**TOWN AND COUNTRY PLANNING SCOTLAND ACT 1997
REPLACEMENT OF TIMBER BACK DOOR AND TIMBER REAR WINDOWS
WITH UPVC EQUIVALENTS IN MATCHING STYLE (SASH AND CASE FOR
WINDOWS). AT 78 STRATHEARN ROAD, MARCHMONT, EDINBURGH, EH9 2AF
REFERENCE NUMBER: 24/00329/FUL**

INCOMPLETE APPLICATION

**Planning Application No: 24/00329/FUL
Scottish Government No: 100657213-001**

Technical Details

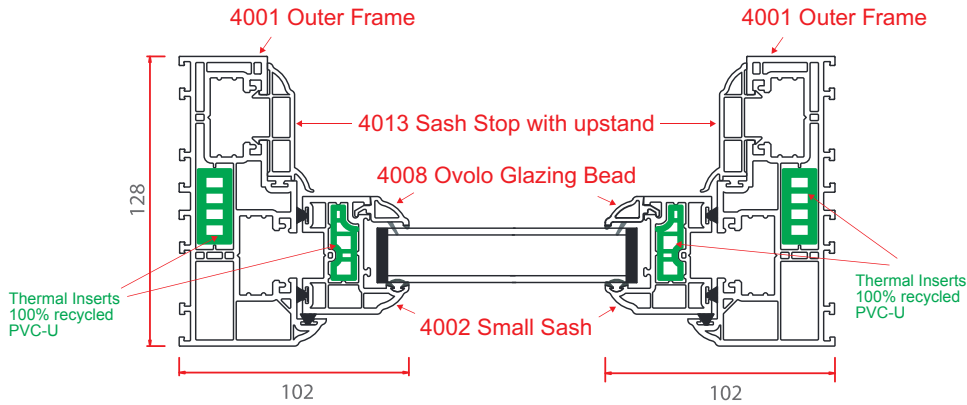
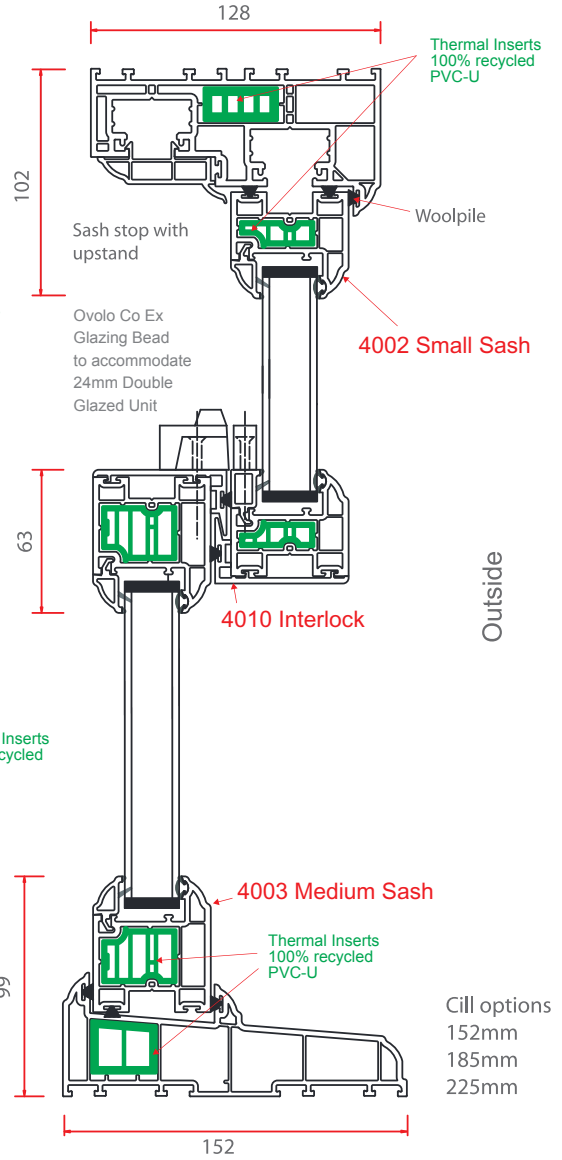
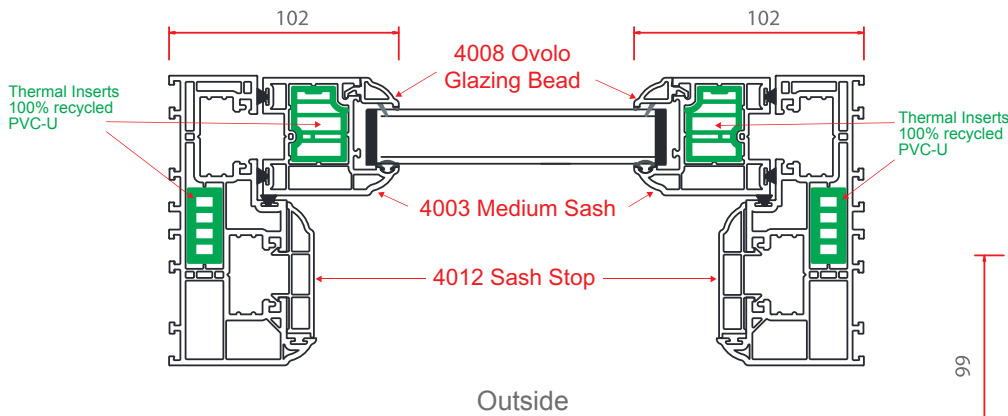
- 01. Proposed window details required - at a scale of 1:50 or 1:100. Please provide a cross section drawing of the proposed windows. See Validation Guidance below.**
- 02. Please provide a manufacturers brochure/drawings to show how the proposed windows/door will look.**
